Application No: AB/21/21/HH
Site Address: 164 Fitzalan Road Arundel BN18 9JZ
Description of works: Erection of a single storey outbuilding to rear.

Thank you for your internet representation made on 29th March 2021 which has been recorded as an objection with the comments as follows:

SITE: 164 FITZALAN ROAD, BN18 9JZ		1 DRAWING NO.		/ PROJECT NO.		22/02/2021 DATE.		NOTE: DIMENSIONS GIVEN IN MILLIMETERS
TITLE: GROUND FLOOR PLAN		1:50 SCALE AT A4.		VC DRAWN.		A REVISION.

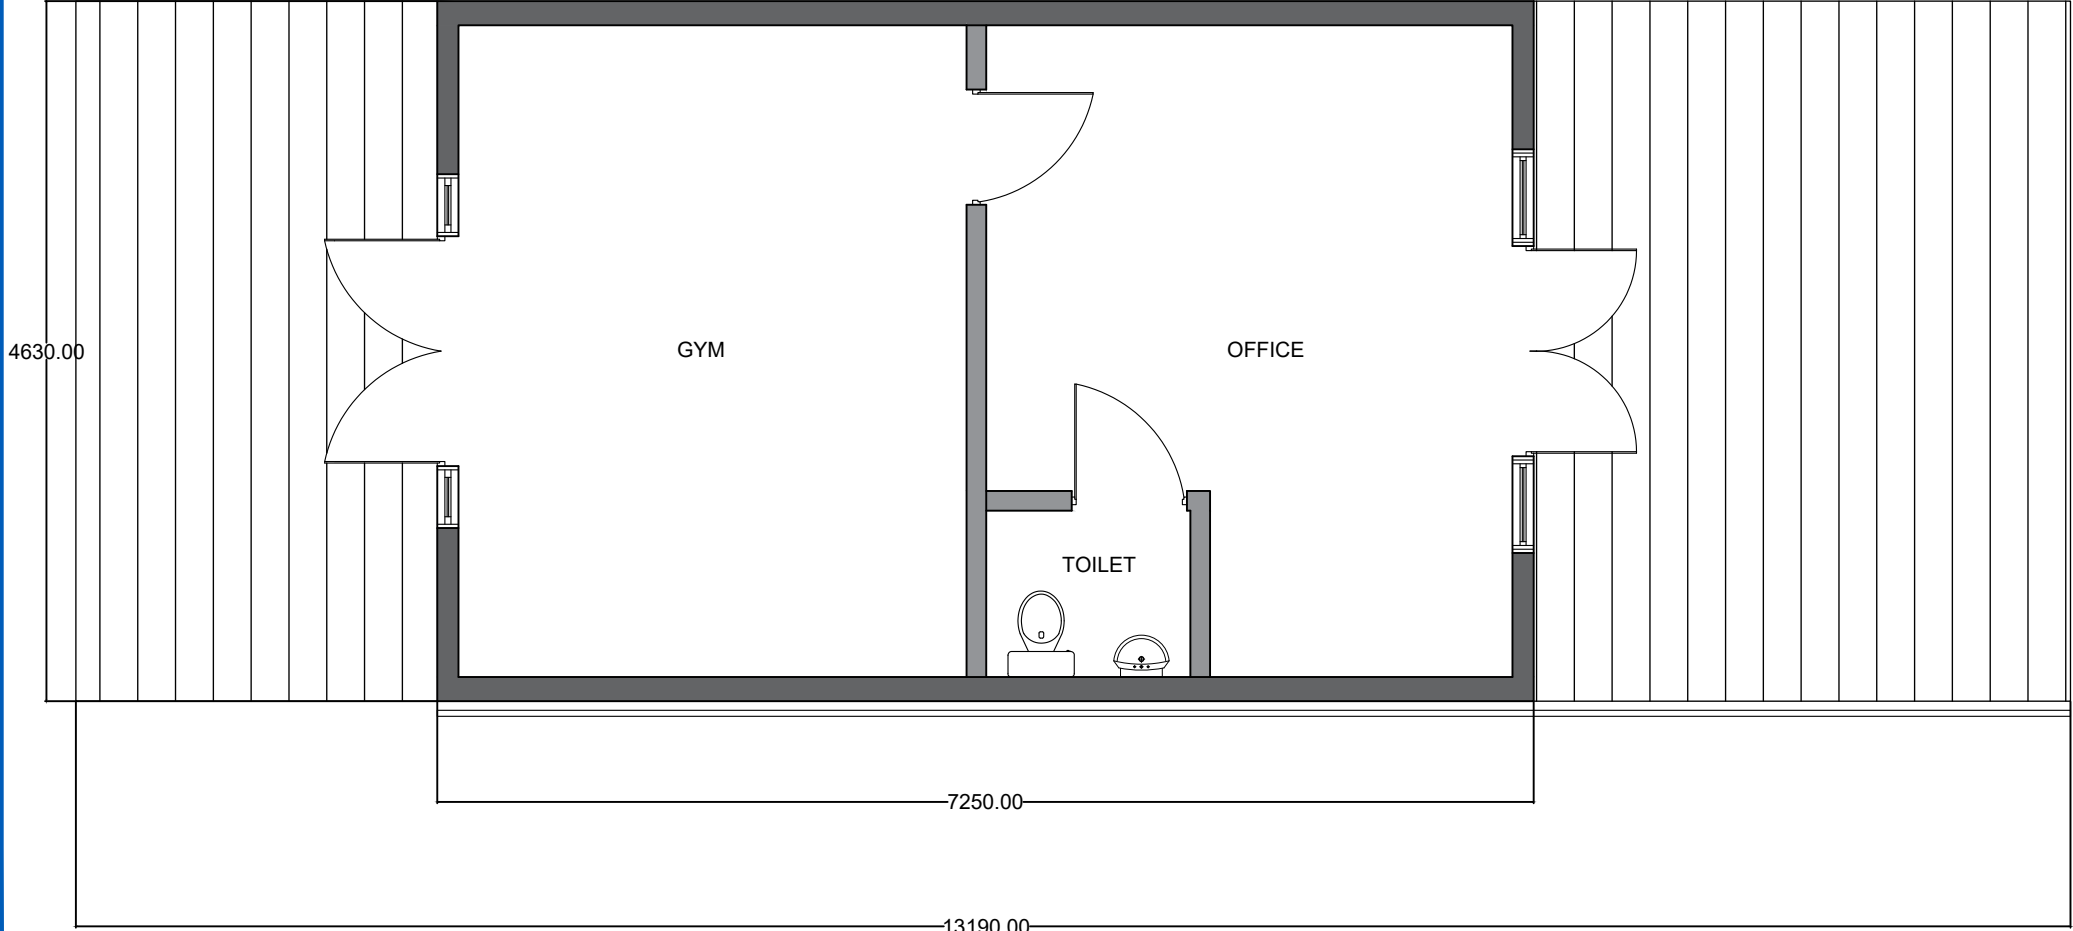
The Committee objected to the application on the grounds of installing WC facilities and the height and mass of the building.
